**EPA Advice on Environmental Impact Statement – SSD 07_0031 - MP07_0031-Mod-1
Tomago Asphalt Batching Plant**

Thank you for the request for advice from Public Authority Consultation (PAE-32282460), requesting the review by the NSW Environment Protection Authority (EPA) of the Environmental Impact Statement (EIS) for the proposed modification to the Tomago Asphalt Batching Plant (Application (SSD) 07_0031) (MP07_0031-Mod-1) at 25 to 27 Kennington Drive, TOMAGO NSW 2322.

Figure 6 Maximum predicted 99th percentile 1 hour odour concentrations

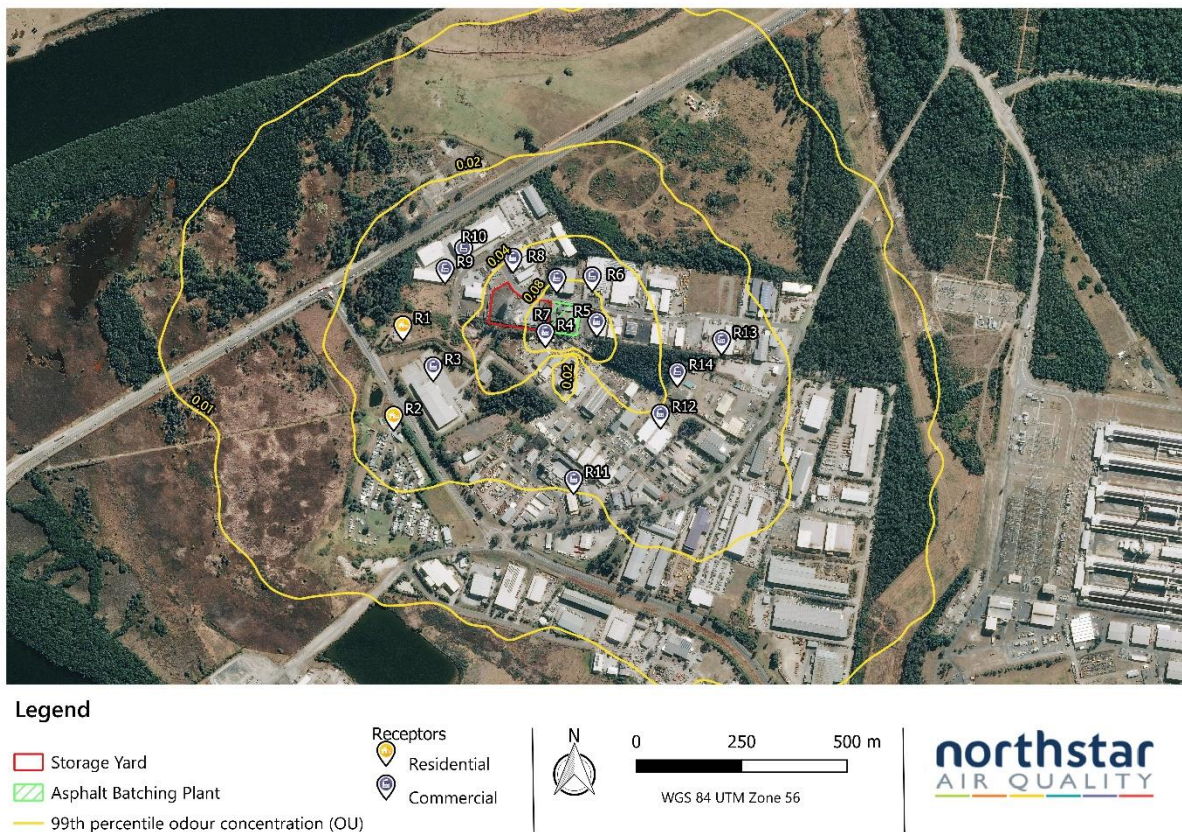
The EPA recommends that the proponent evaluate the odour risk of the activities, specifically addressing the uncertainty in the modelling, and identifies the additional reasonable and feasible controls that could be applied should odour become an issue once the increase in throughput occurs.

Modelling of odour impacts in the AQIA predicts less than 1 OU beyond the boundary. However, limited emission sources were included in the assessment. Only the dryer stack was included in the modelling and no fugitive sources such as loading/drop points. Further the assessment relies on old and limited measured odour data from the dryer stack and does not capture the potential variability of emissions from a batching process. These issues combined with the inherent uncertainty in odour modelling, the results presented do not provide for adequate evaluation of impacts and that no offensive odour beyond the boundary will occur.
